Recommendation Report for Planning Permission

REF NO: FP/203/17/PL

LOCATION: 7 Middleton Road
Felpham
PO22 6BL

PROPOSAL: Demolition of outbuildings & erection of 1 No. dwelling to rear (resubmission following FP/137/17/PL).

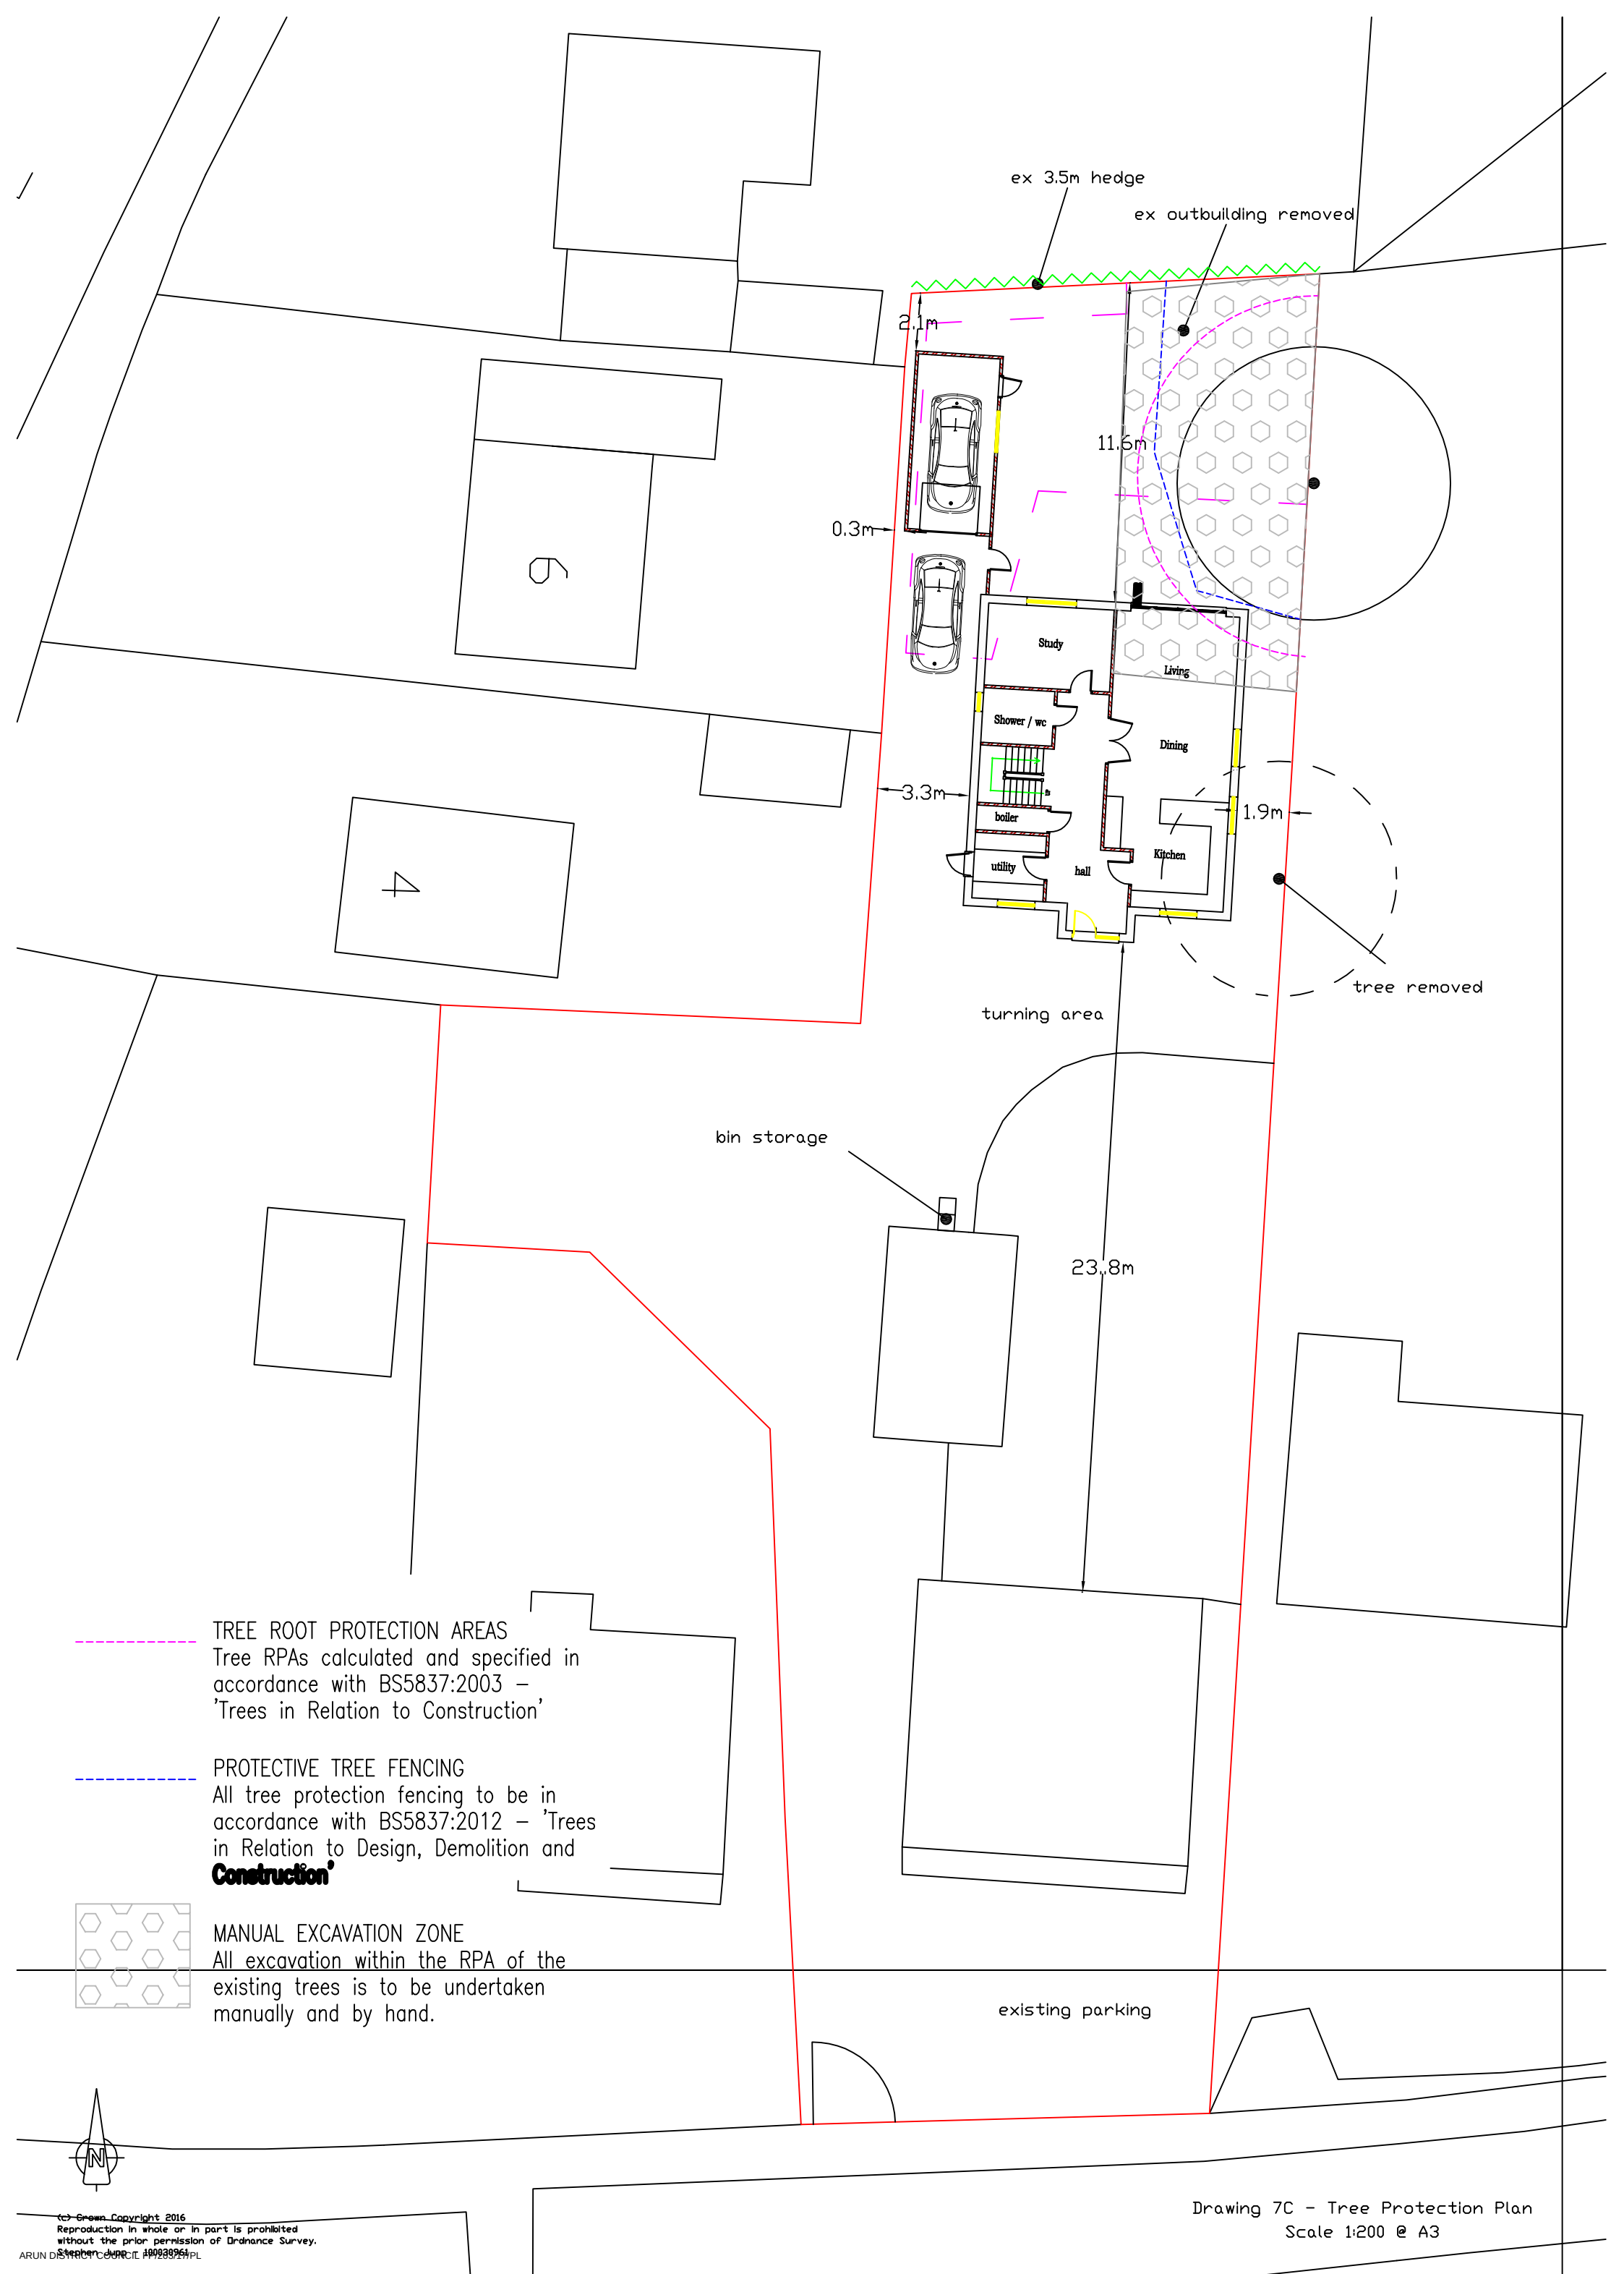
ADC TREE OFFICER: Following amendments to the submitted tree protection plan and arboricultural impact assessment report, is now satisfied with the scheme and recommends approval subject to a condition requiring that the scheme be implemented in accordance with the submitted report and tree protection plan.

The application proposes to fell one existing Birch tree. This has been accepted by the Council's Tree Officer and following the provision of a tree protection plan detailing measures to protect the Horse Chestnut on the other side of the eastern boundary, no objections have been raised. The support of the Council's expert on trees and tree protection is therefore considered to satisfy the requirements of policy ESD9.

- 3 All demolition & construction works are to be carried out in strict accordance with the submitted Arboricultural Impact Assessment Report by Stephen Jupp dated 29/09/17 and the submitted Tree Protection Plan ref: Drawing 7D-1:200 @ A3.

DRAWING
05C

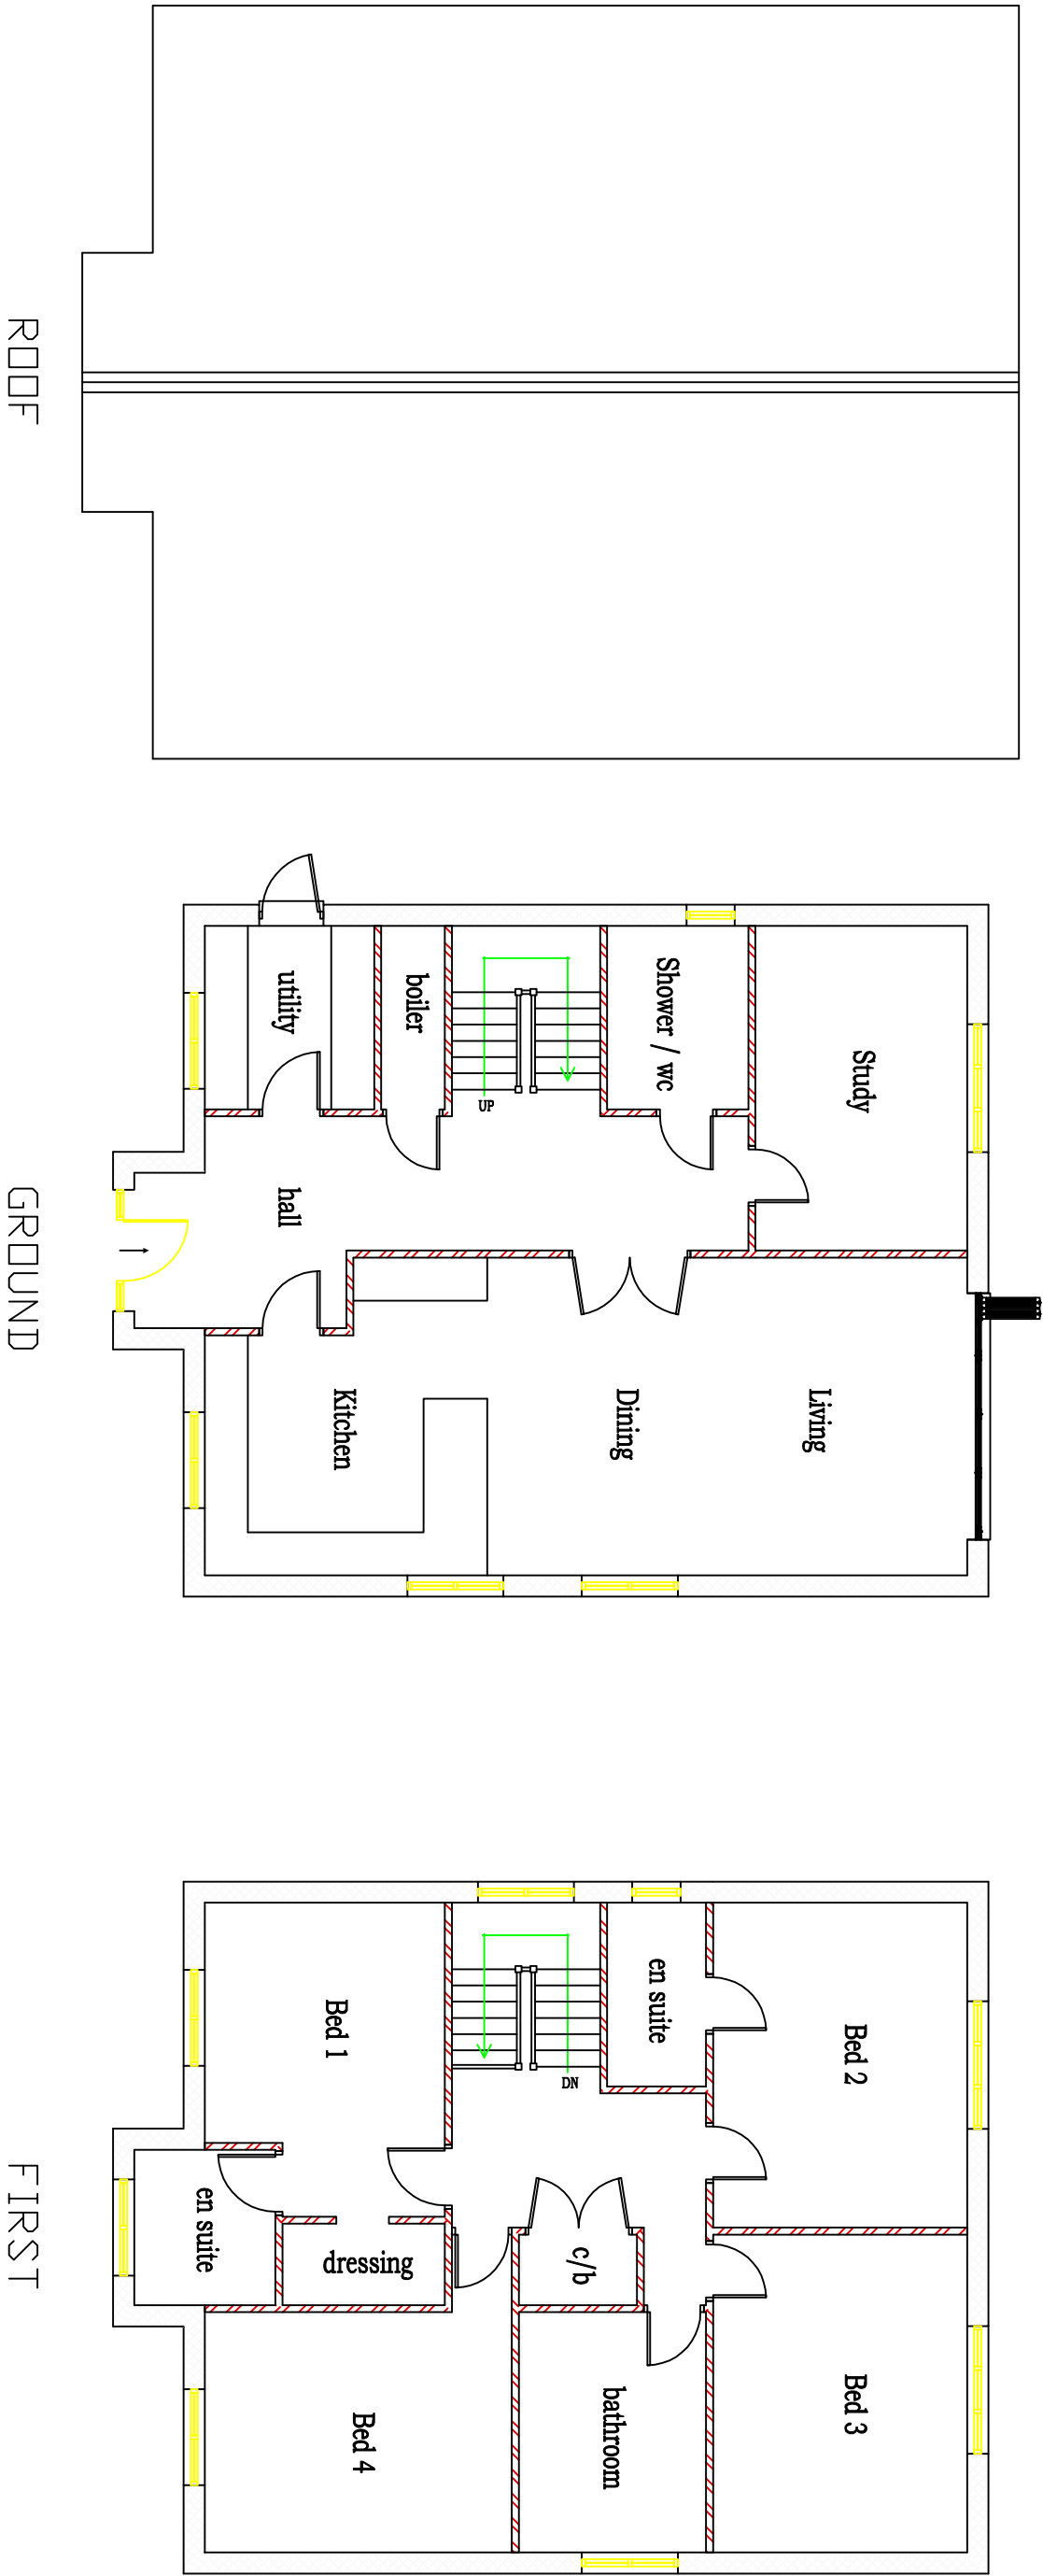
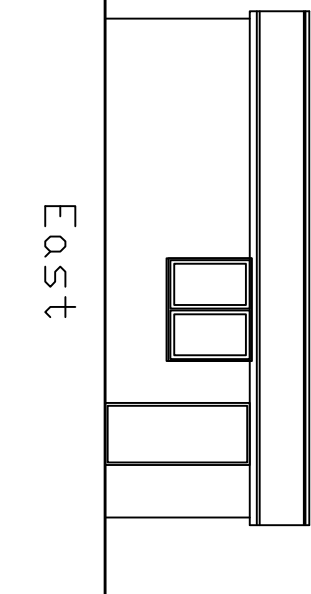
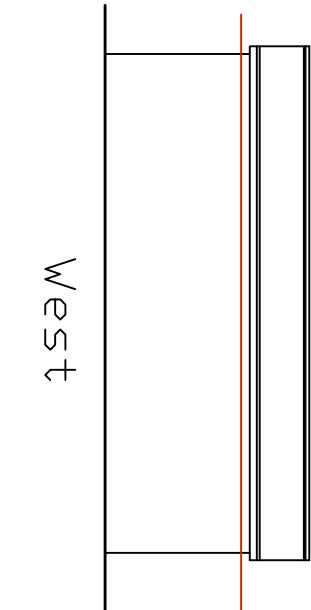
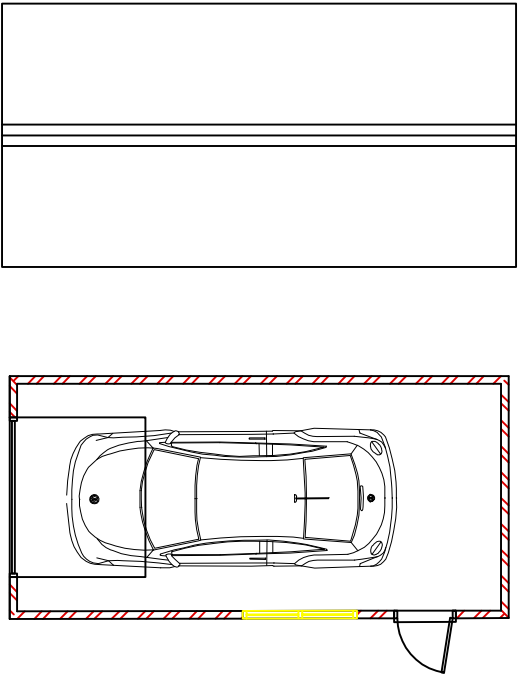
The proposed dwelling would be side on to the rear elevations of two houses fronting Flansham Lane. It will be approximately 12.4m from the original rear elevation of no. 6 and 14.4m from the rear of no. 4. The drawings show that there will be two windows on this elevation but that these will be obscure glazed and permanently fixed shut. Therefore, these windows will serve only to provide light to the proposed dwelling and as such there will be no overlooking of the existing rear windows of 4 or 6.

- 8 The proposed first floor landing and en-suite bathroom windows on the western elevation of the building shall at all times be glazed with obscured glass and fixed to be permanently shut as per the submitted drawing 05C.

- 9 The proposed first floor bathroom and en-suite bathroom windows on the eastern and southern elevations shall all be permanently glazed with obscured glass.
